**RE: McDonalds – Coors and Hanover
1501 Coors Blvd NW
Grading Plan Engineer's Stamp Date: 2/28/17
Hydrology File: J11D037**

Based upon the information provided in your submittal received 3/9/17, the Grading Plan is approved for Building Permit, Grading Permit, and Paving Permit.

RE: McDonald's 1501 Coors Blvd.
File # J11-D037

C8.2

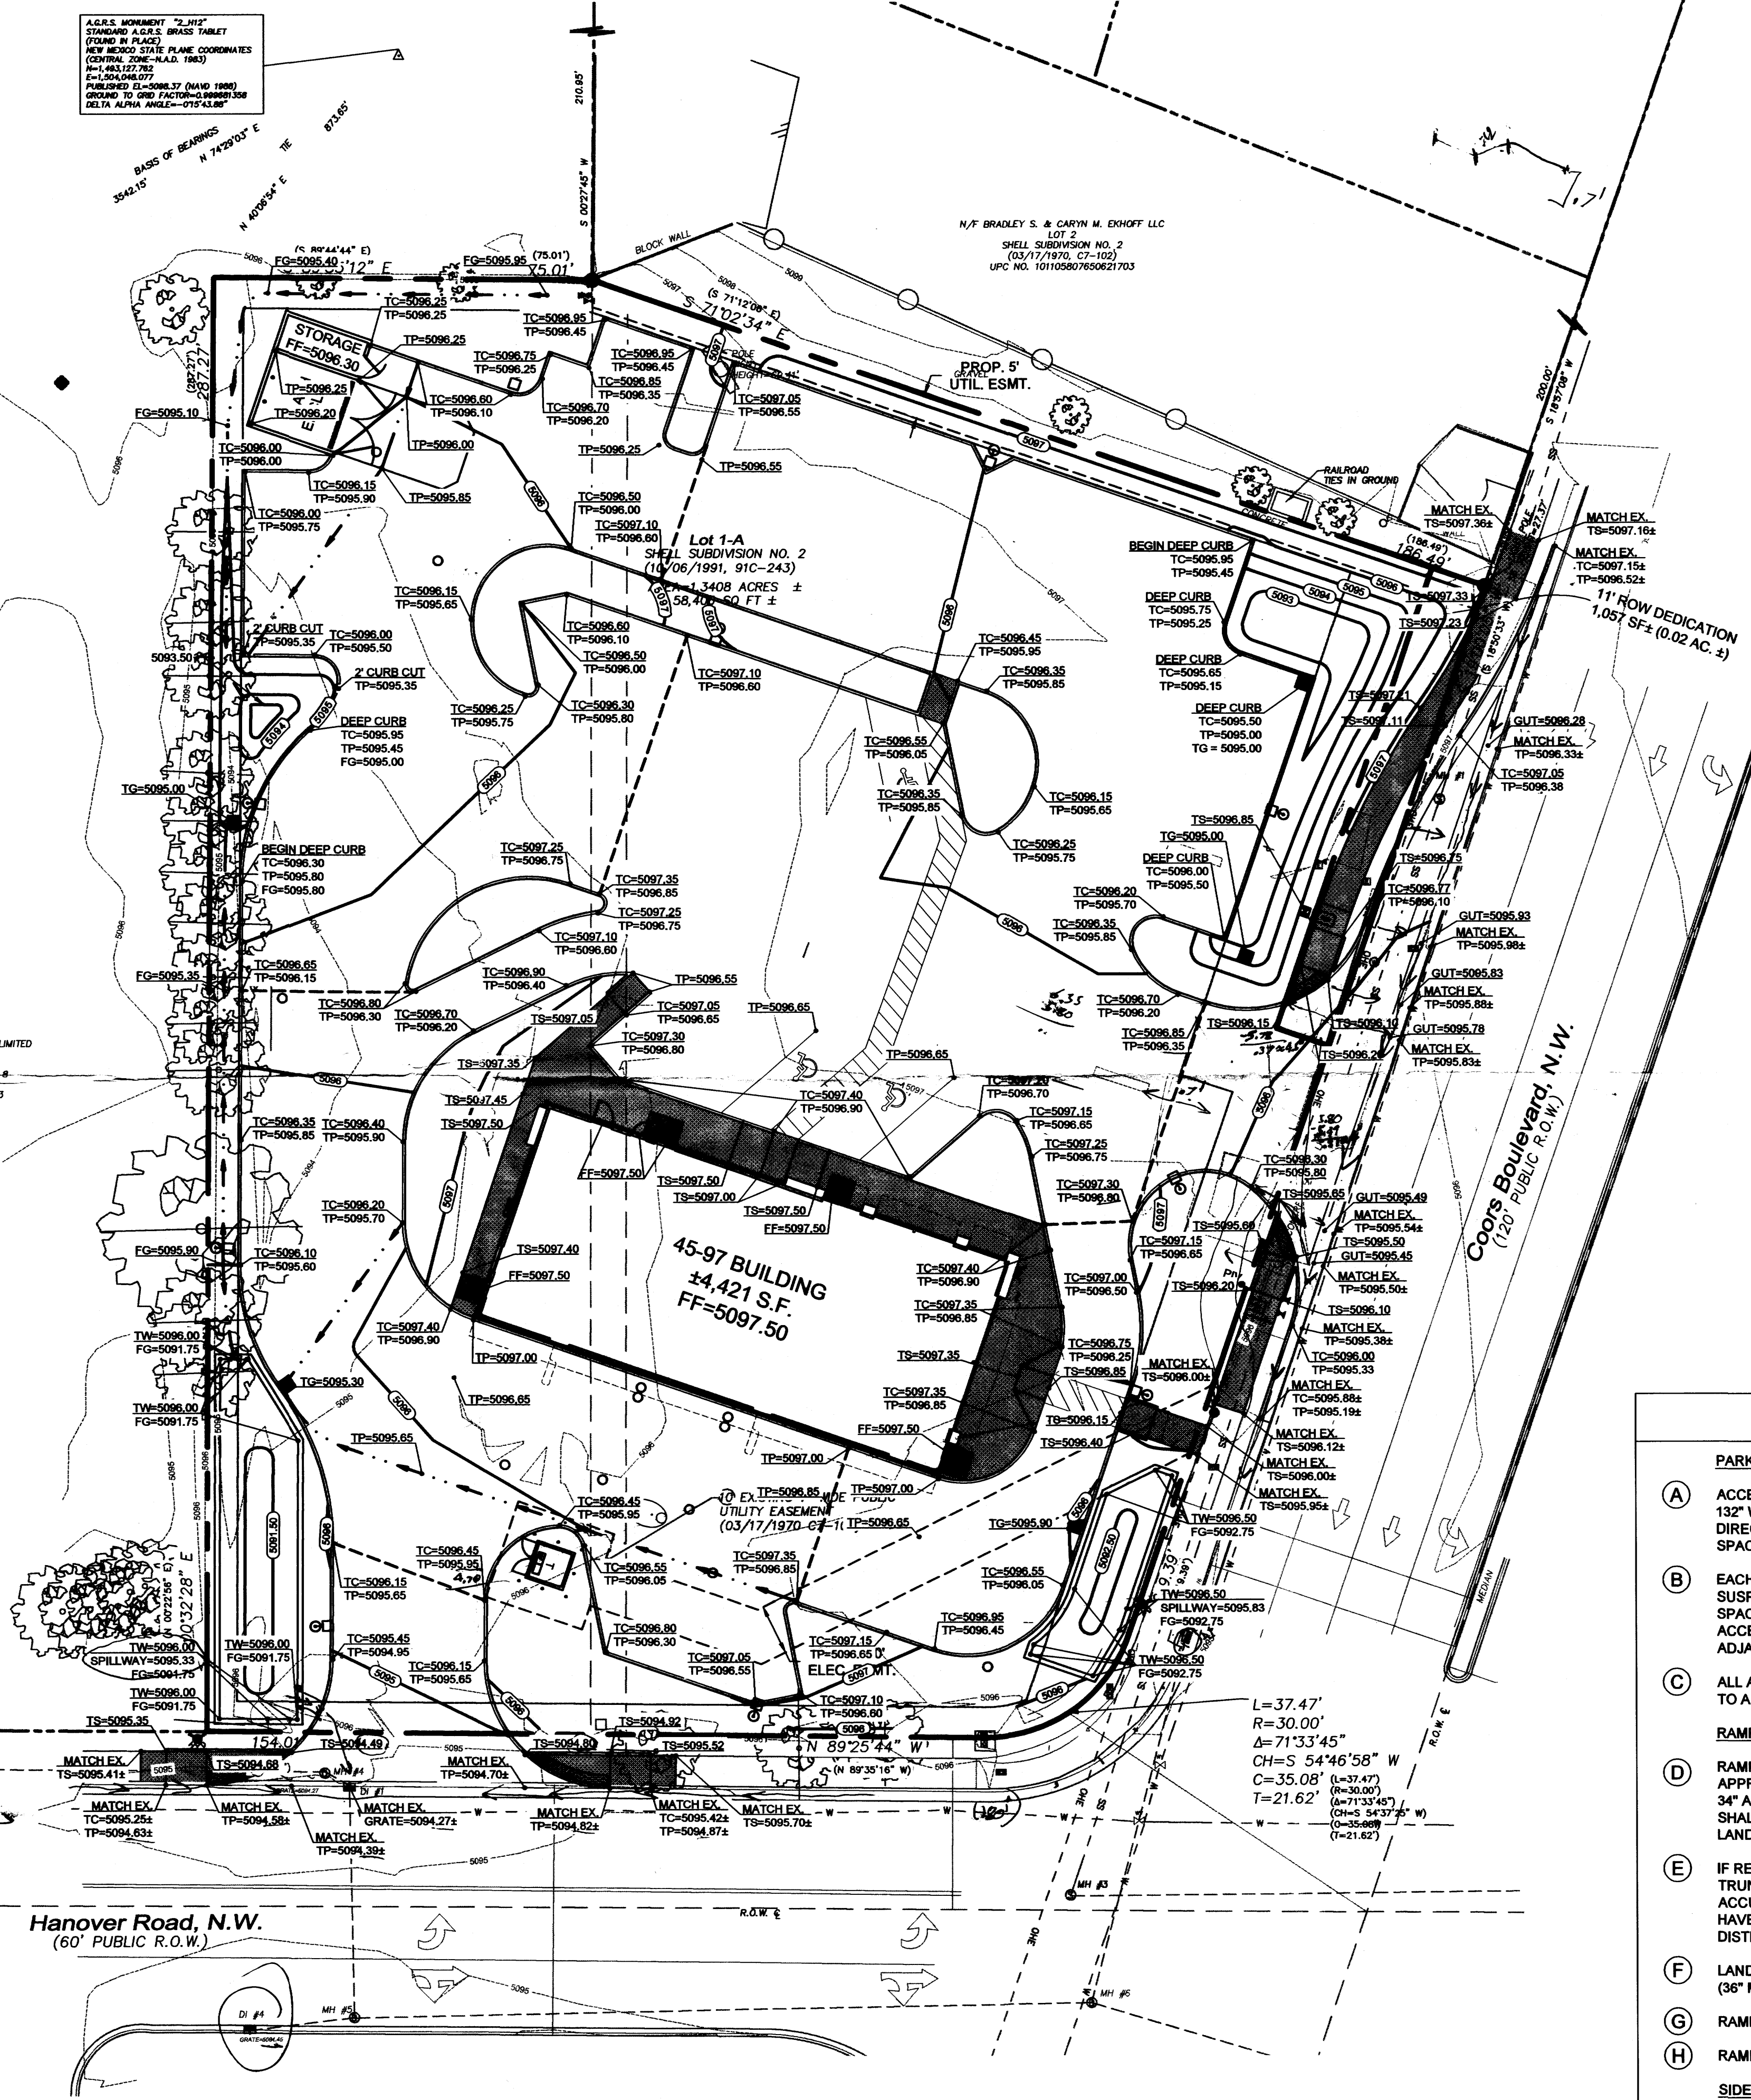
- ✓ • We have added a note for MH#4 to be lowered to match proposed top of pavement.
- ✓ 4. Ensure the fence around Bio-retention Areas 3 and 4 is at least 42" in height.

- The fence around Bio-retention Areas 3 and 4 will be 4' tall. The detail is shown on Sheet C10.4 Standard Details.
5. Waterblocks, at least 8" high from top of pavement on the drivepad to bottom of gutter along the road, need to be incorporated at the Coors entrance. Correspondence is attached.
